May 2, 2022

RE: Proposed Minor Amendments – Walmart Neighborhood Market – 1820 Unser Blvd. NW

SECP-1

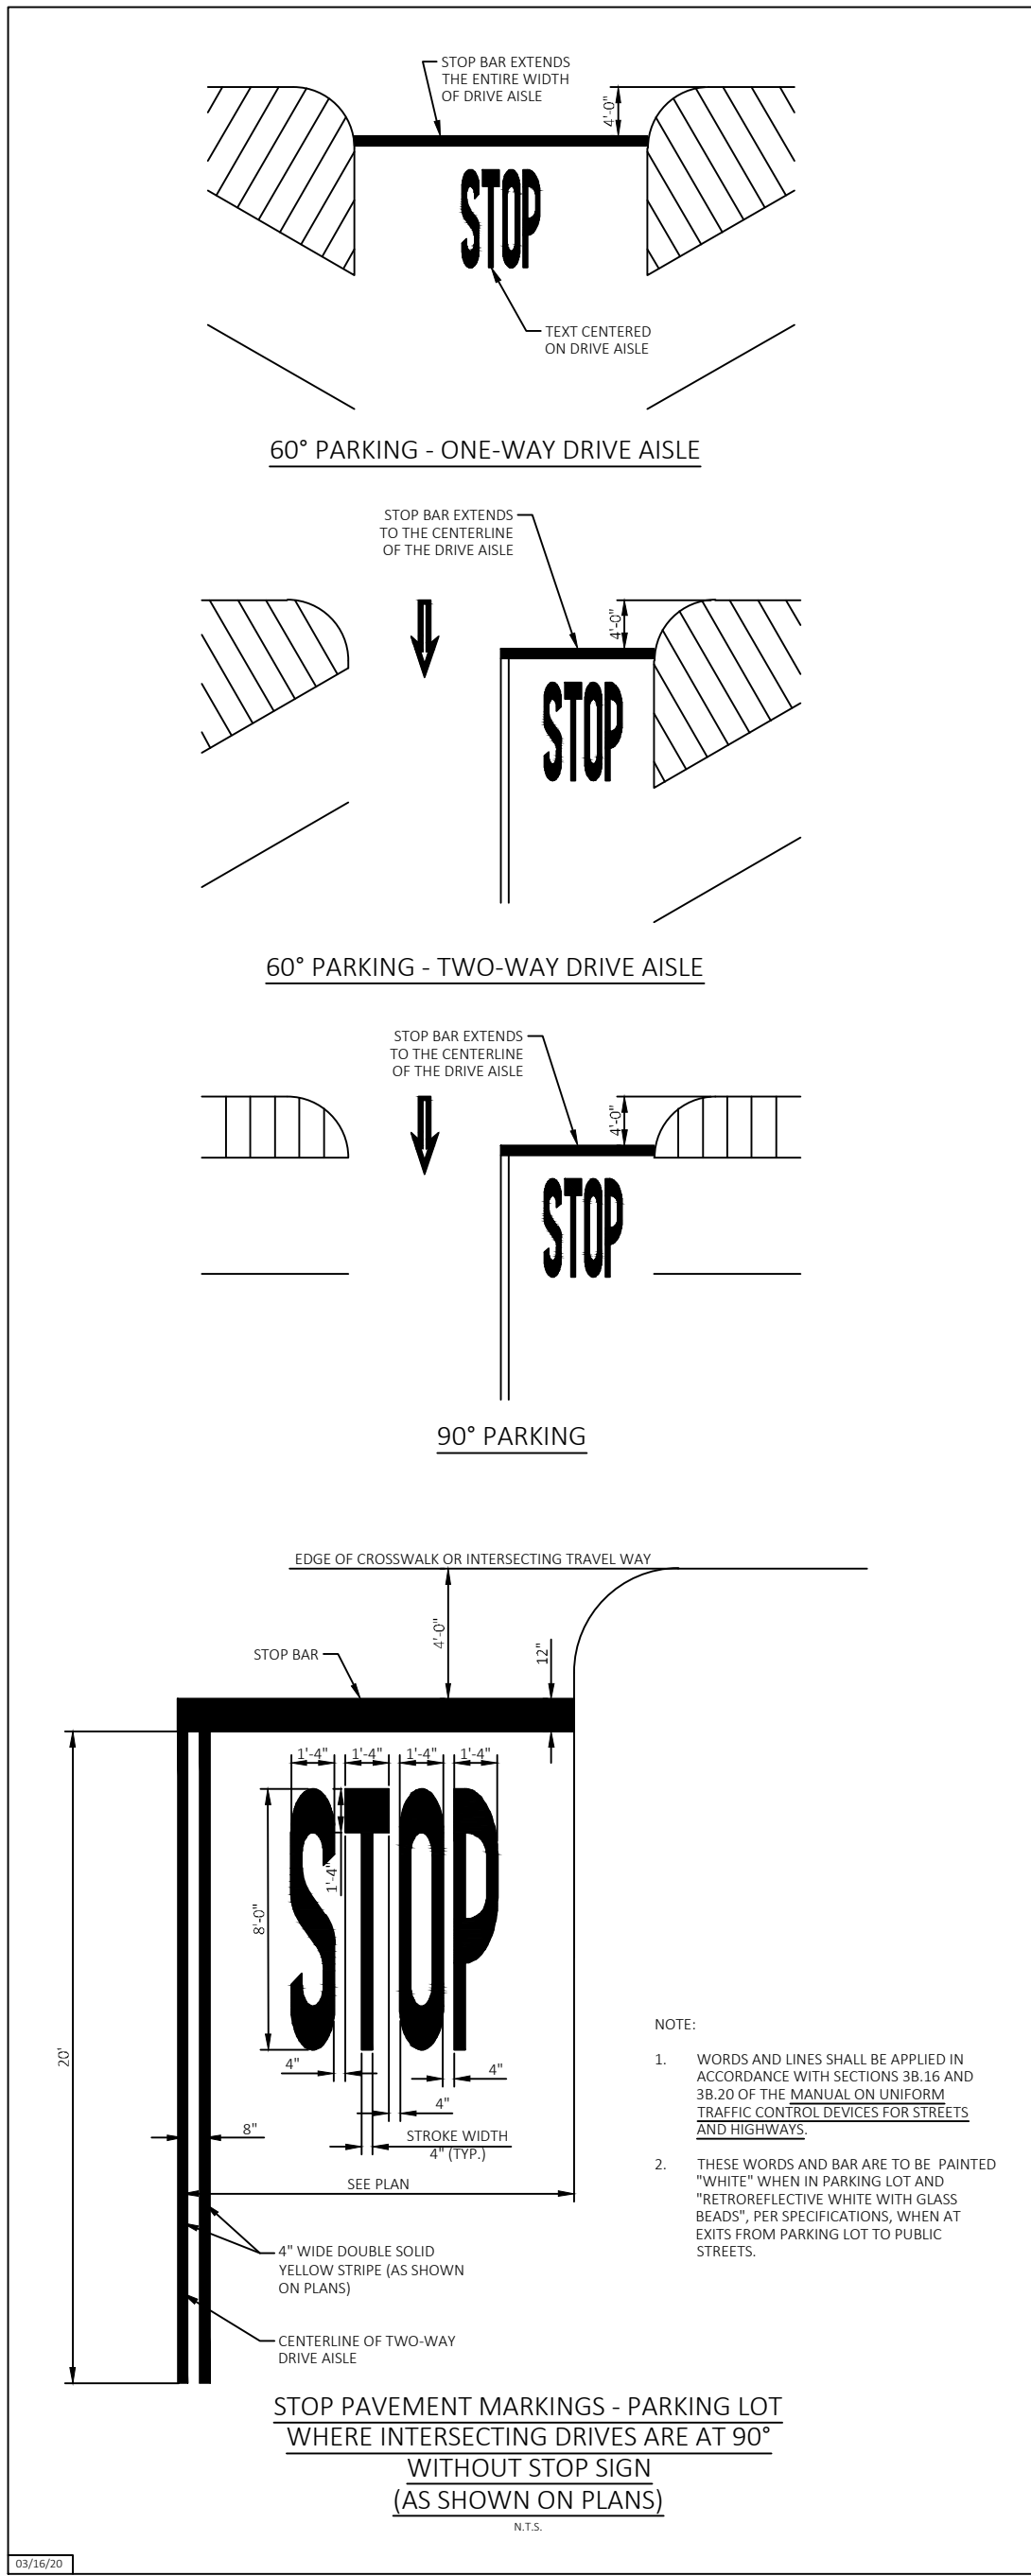
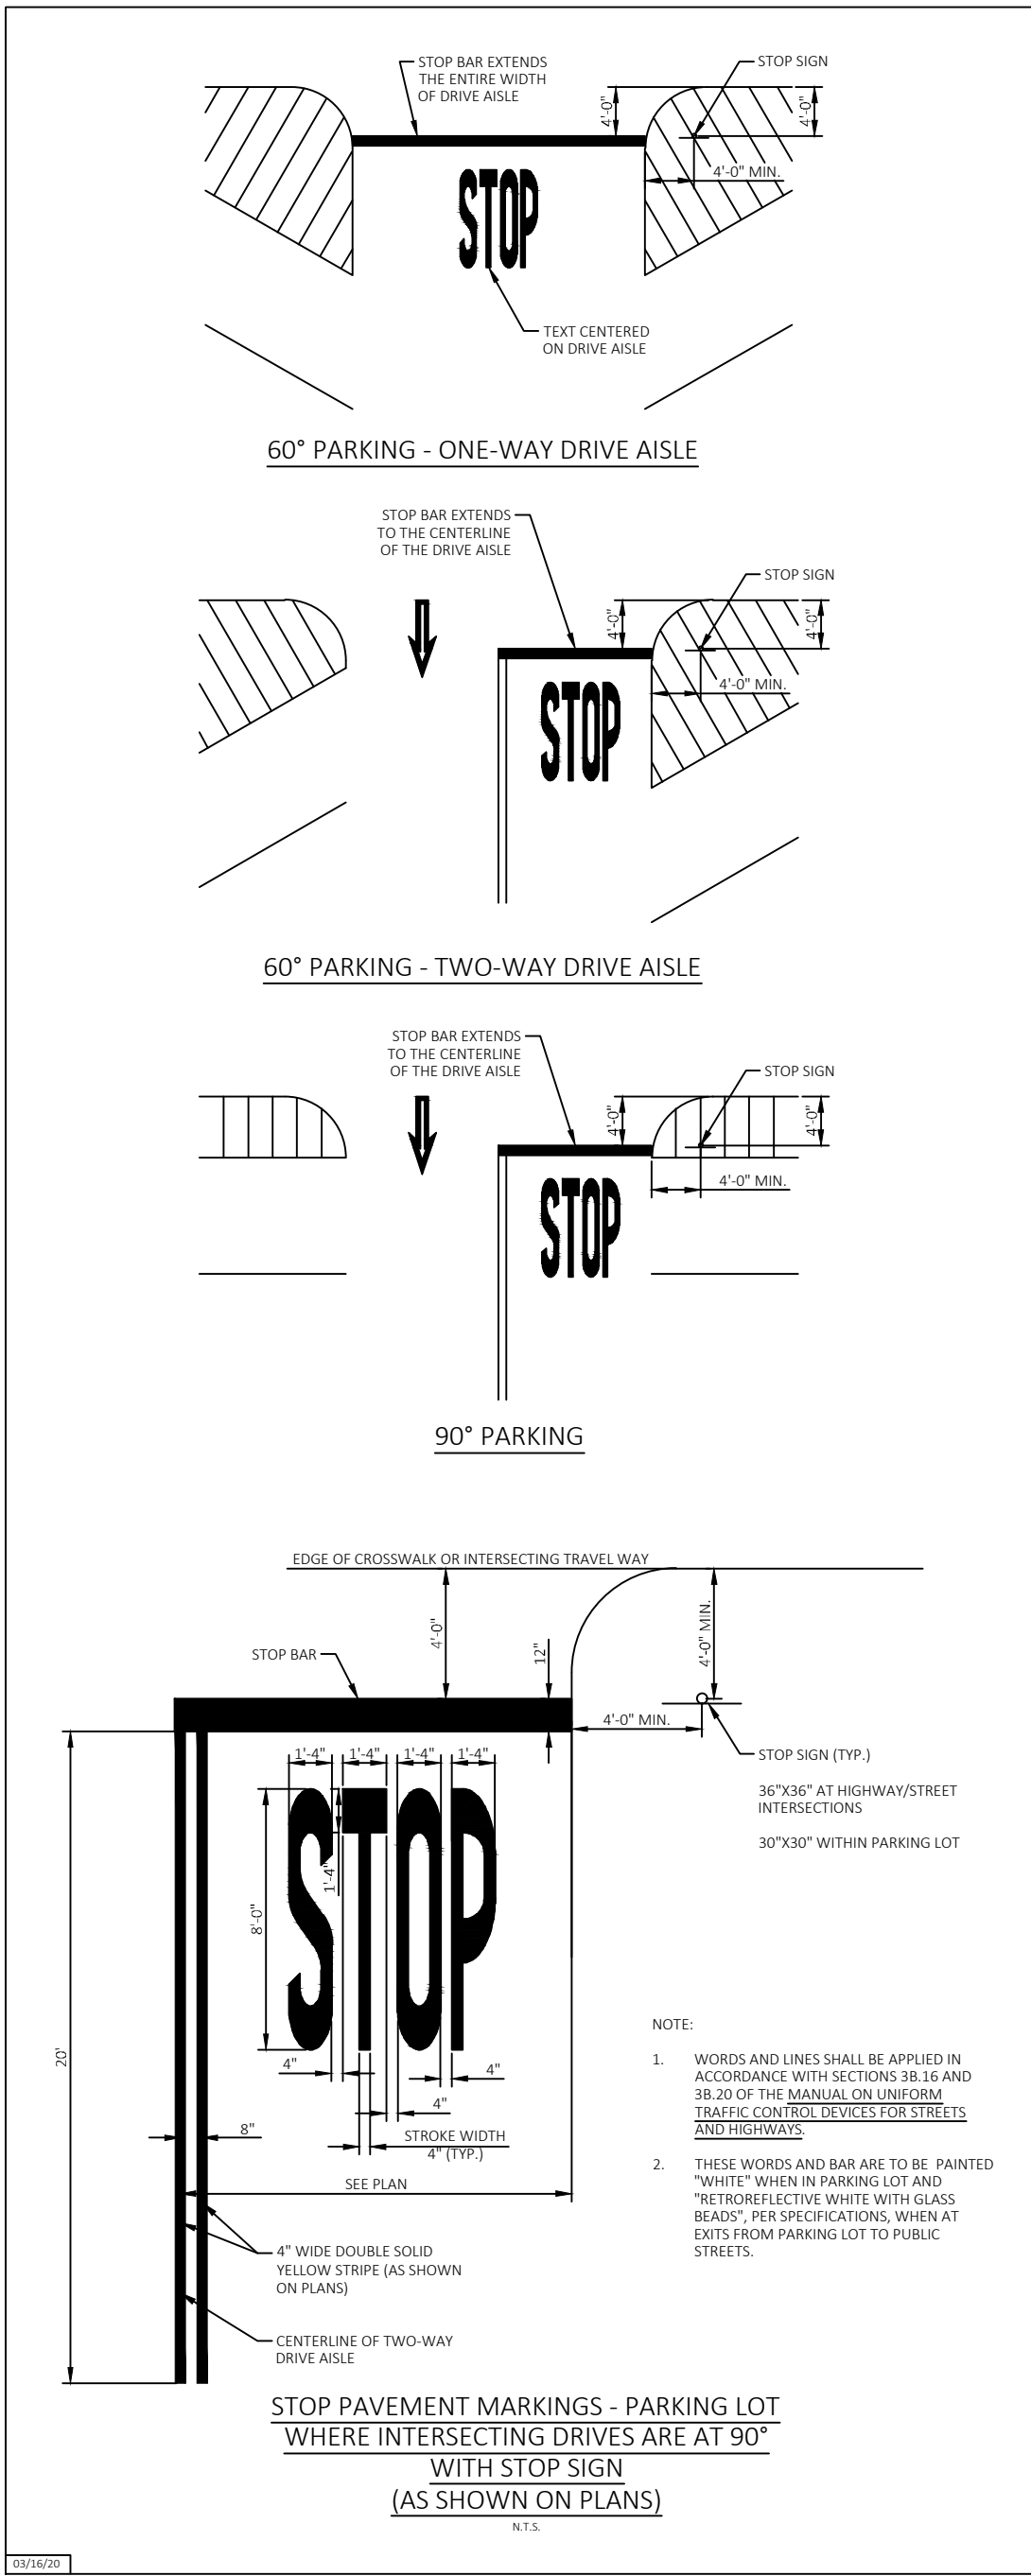
Sheets A2, A2-1, A21.1, CS1, CS1A, CS2, CS3, SSM, SECP-1, SECP-2 (pdf pages 5 through 14). The 8/24/2021 approval stamp (pdf page 15).

Here's where I run into problems: the PROPOSED site plan, which will get stamped to supersede the Existing site plan, MUST CONTAIN THE EXACT SAME SHEETS. Instead, the proposed site plan only has Sheets A2, A2-1, SSM-1, SECP-1, and SECP-2. Therefore, it's incomplete.

Could you please send, via separate .pdf, a copy of the stamped, existing site plan with the new changes marked on it? The sheets must be the same and the new changes, proposed Spring 2022, need to be clearly shown.
